Recommendation Report for Planning Permission for Works or Extension to a Dwelling

REF NO: AL/95/21/HH

LOCATION: 31 St Richards Road
Westergate
PO20 3RD

PROPOSAL: Single storey extension to replace existing conservatory.

GROUND FLOOR PLAN ~ AS PROPOSED

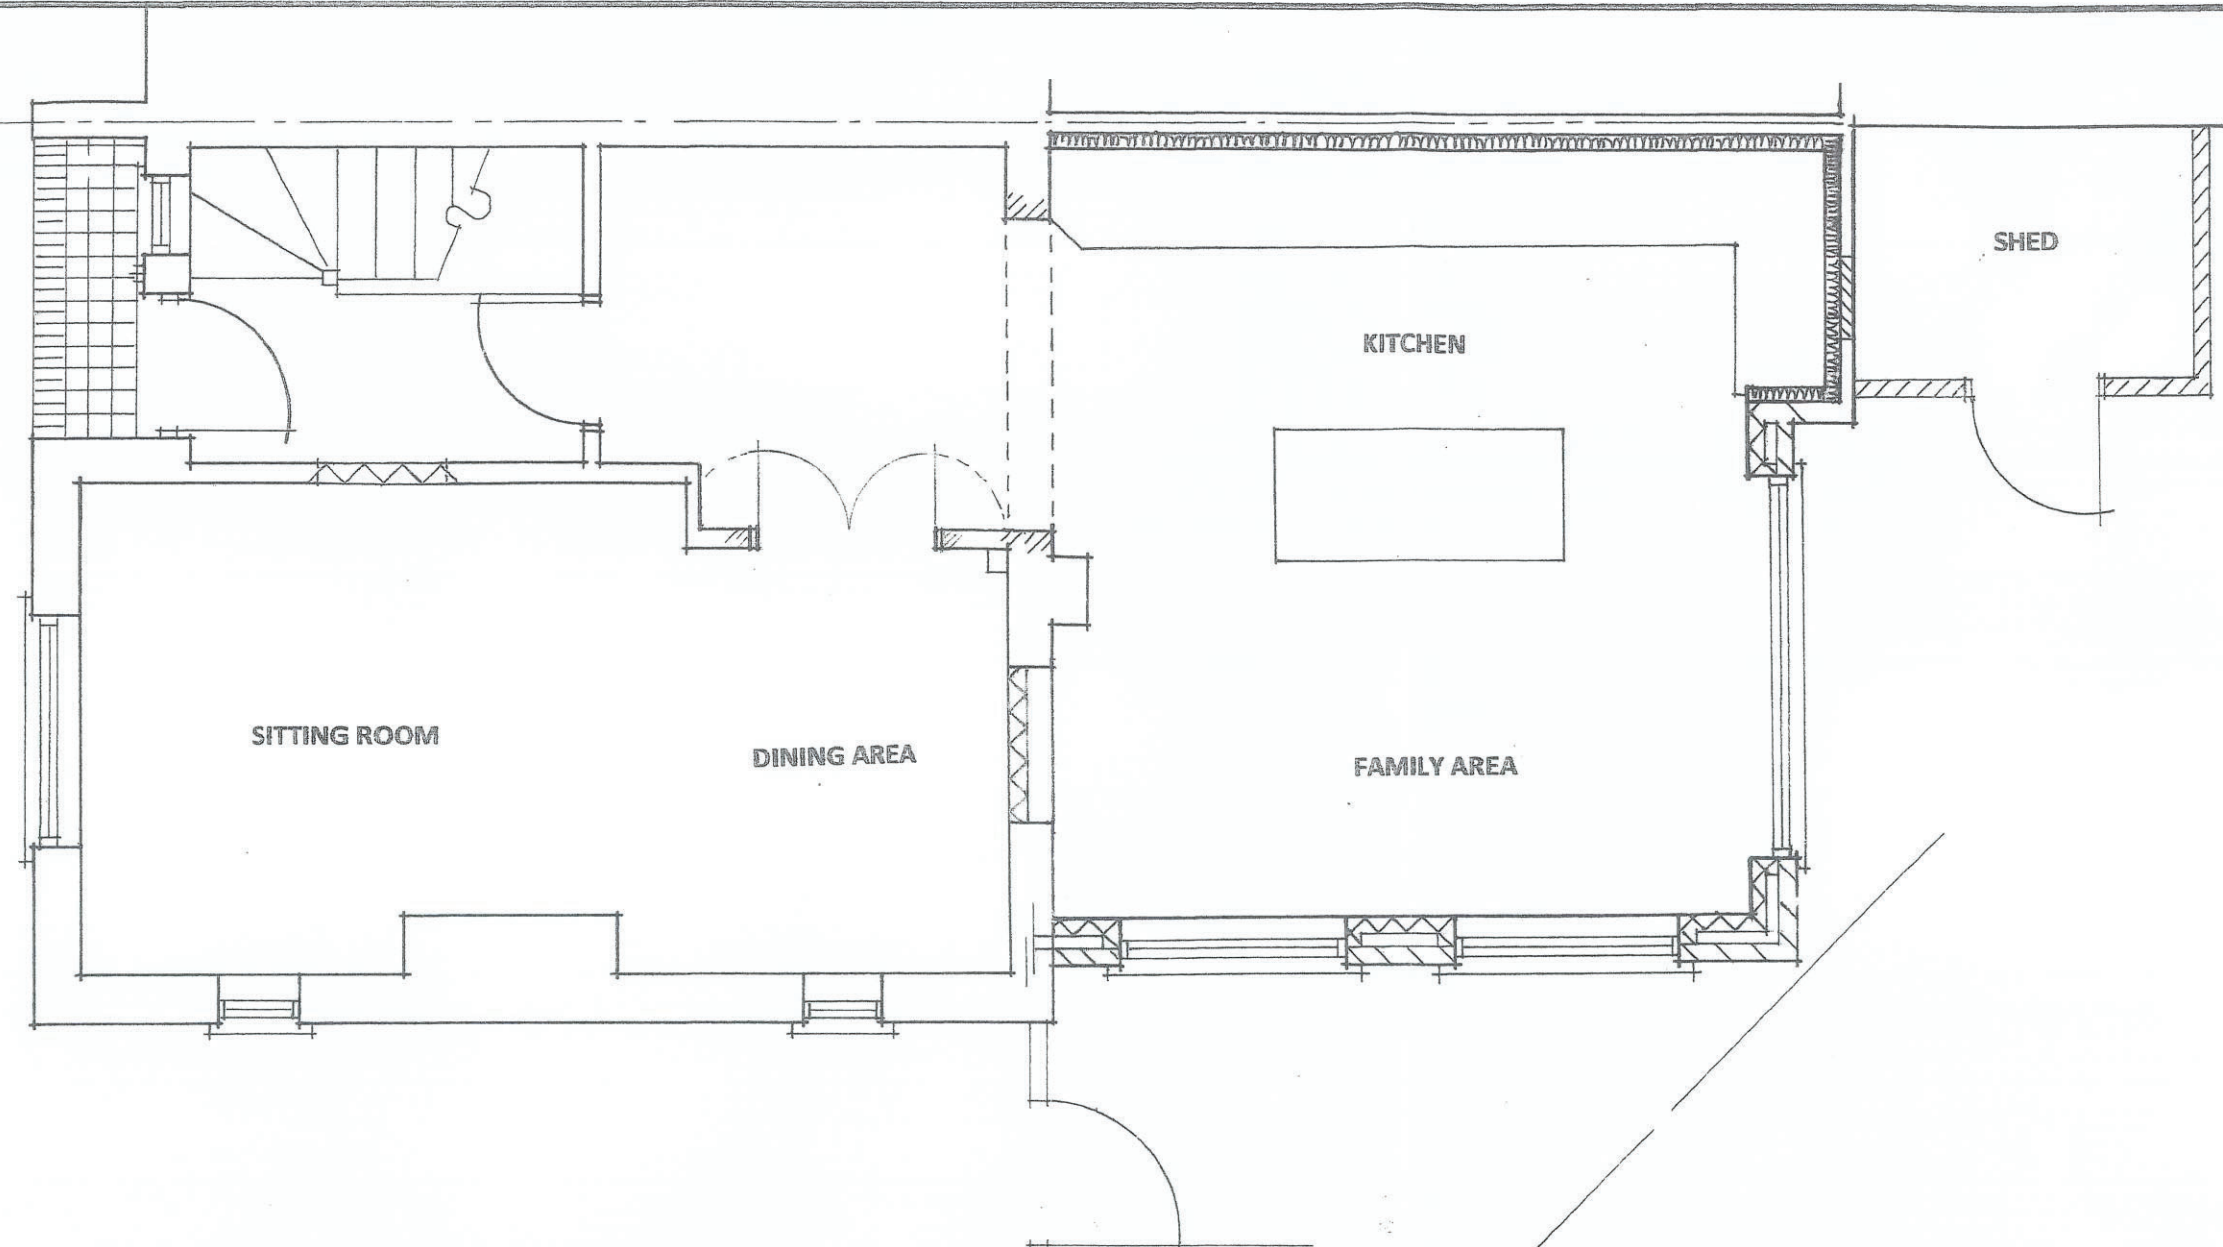
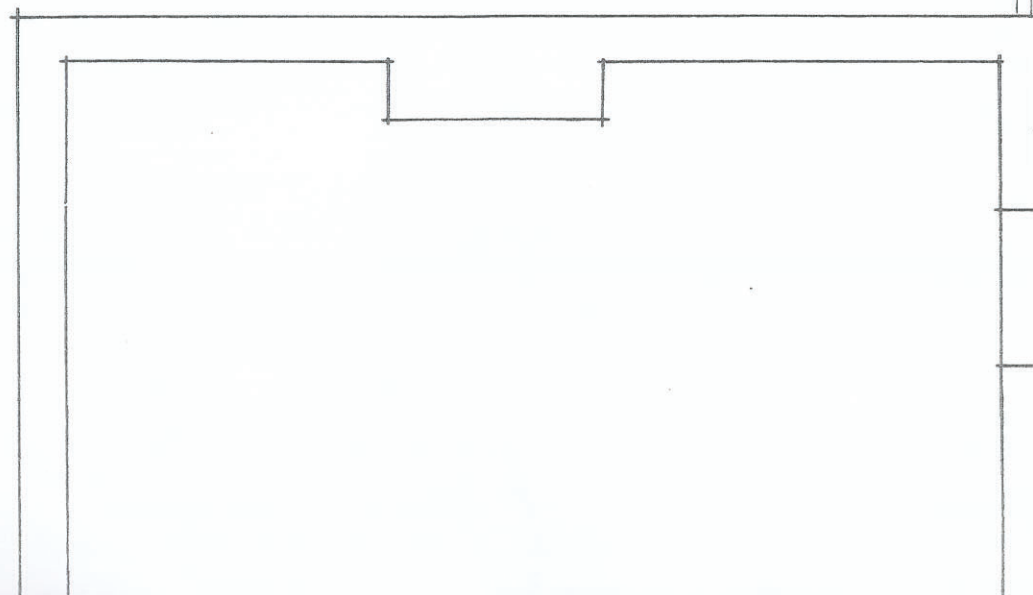
The proposed single storey rear extension will have a width of approximately 3.58m and a depth of approximately 4.94m. The height to top of pitched roof end will be approximately 3.29m. There will be two new windows to south elevation, three sliding doors to rear (east) elevation and one new roof lantern roof light.

The rear extension will run along most of the rear principal elevation. There is around 2.50m remaining to side (southern) boundary fence. Due to extension being similar in width to conservatory being removed there is no adverse harm to overbearing or overshadowing effects to neighbouring property number 33 St Richard Road to south. The proposal retains around 22.1m to the rear (east) boundary so is acceptable.

ROOF PLAN ~ AS PROPOSED

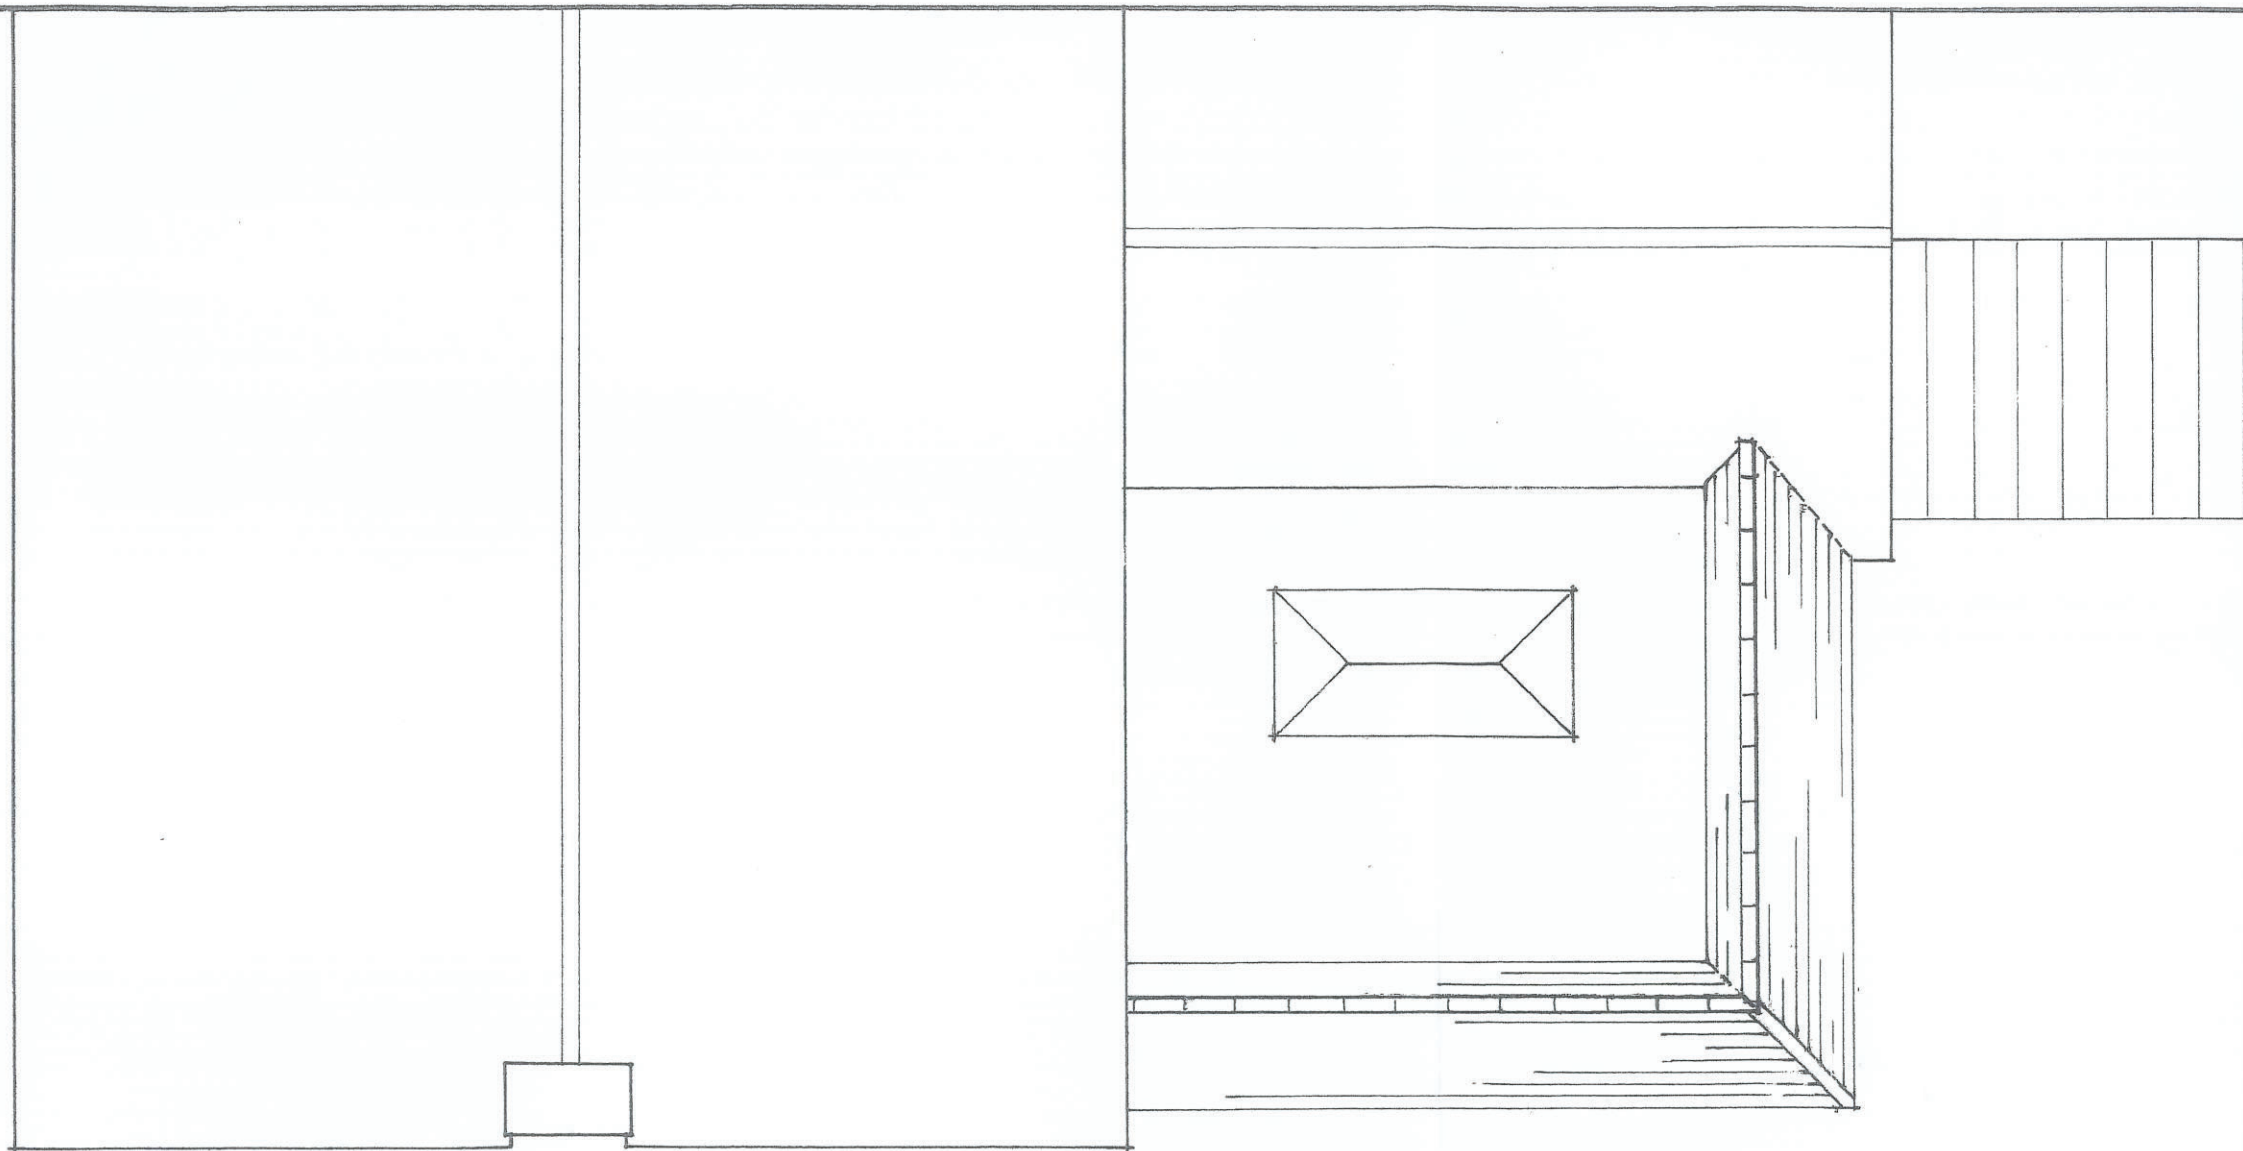
The proposals are for single storey extension to replace existing conservatory. Due to siting to rear (east) the extension is restricted from view from street scene so does not impact surrounding character of area so complies with policy D DM1 of the Arun Local Plan. The roof design is in-keeping with existing property and is visually subservient to main property so complies.

GROUND FLOOR PLAN ~ AS EXISTING

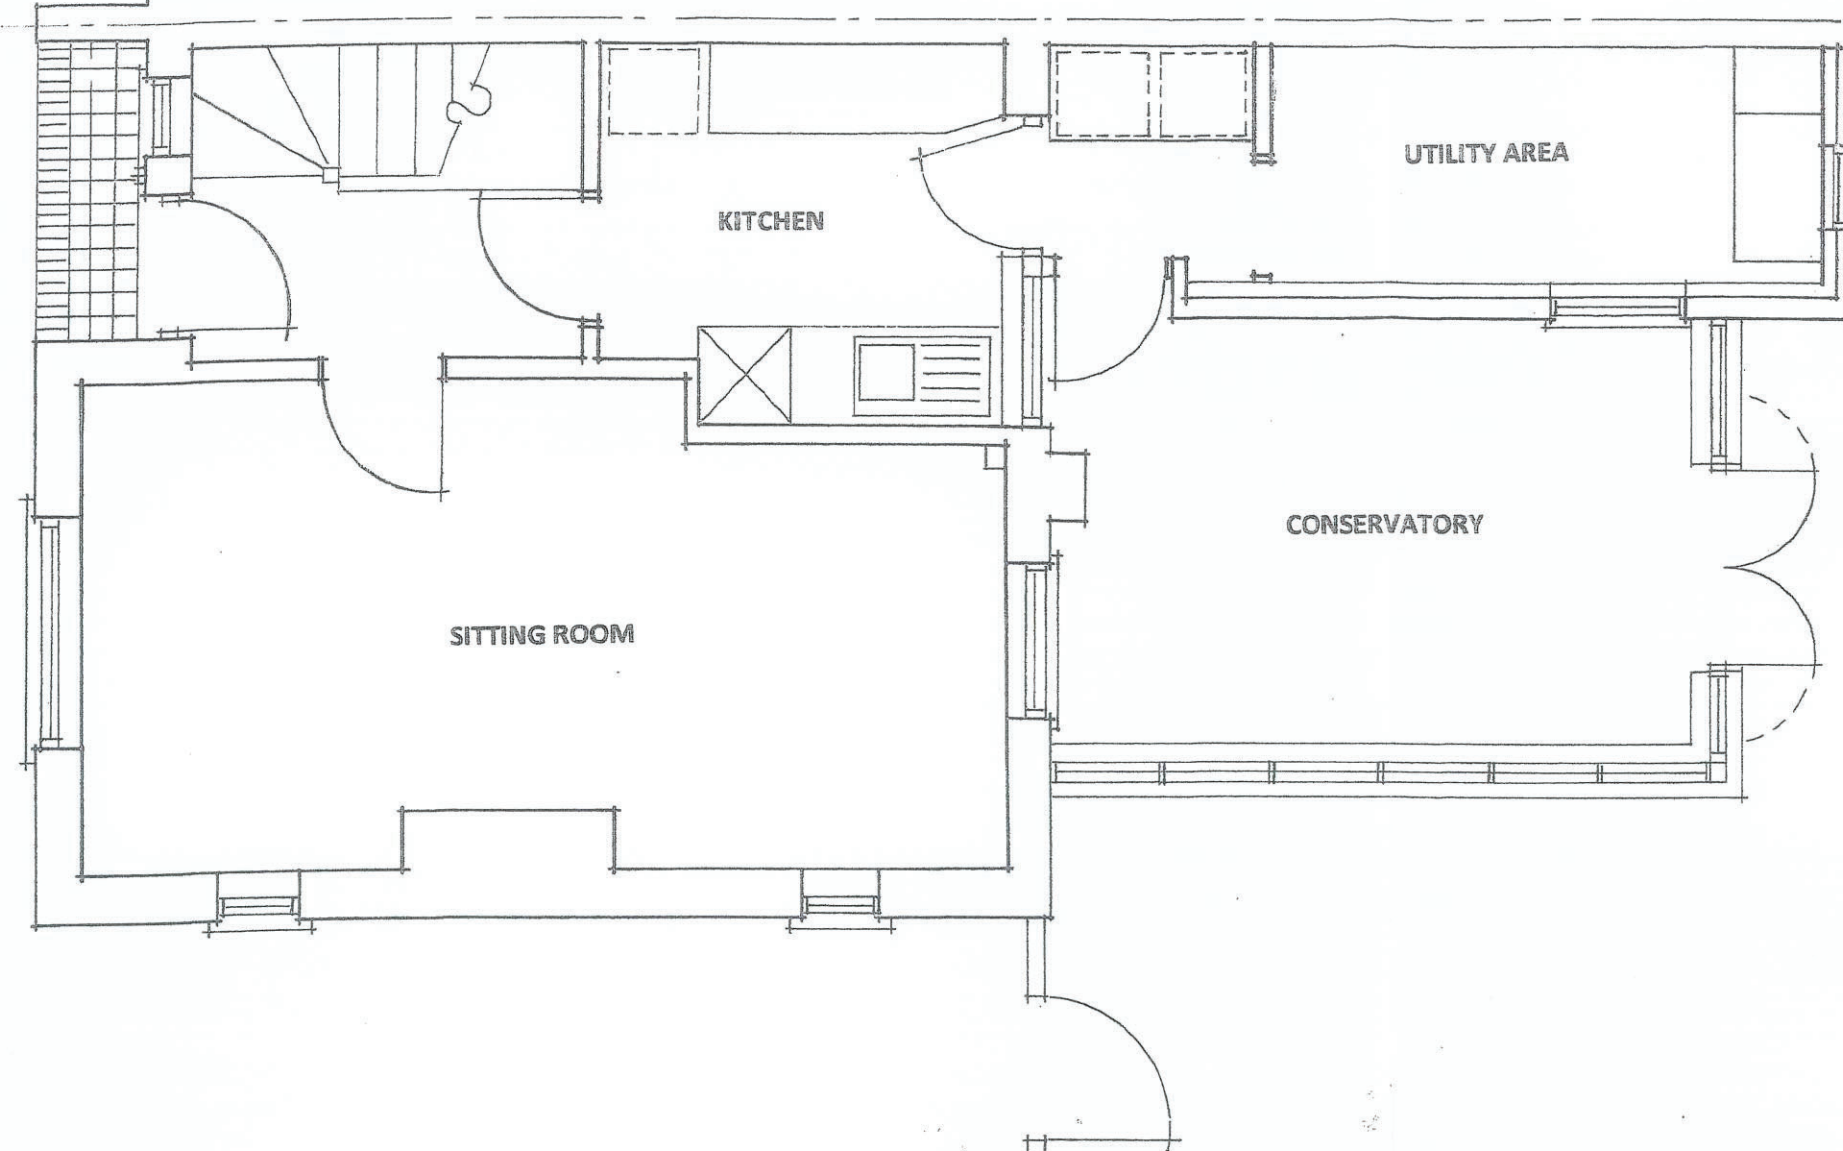
The conservatory to be removed to rear has a width of 3.17m and a depth of 4.58m.
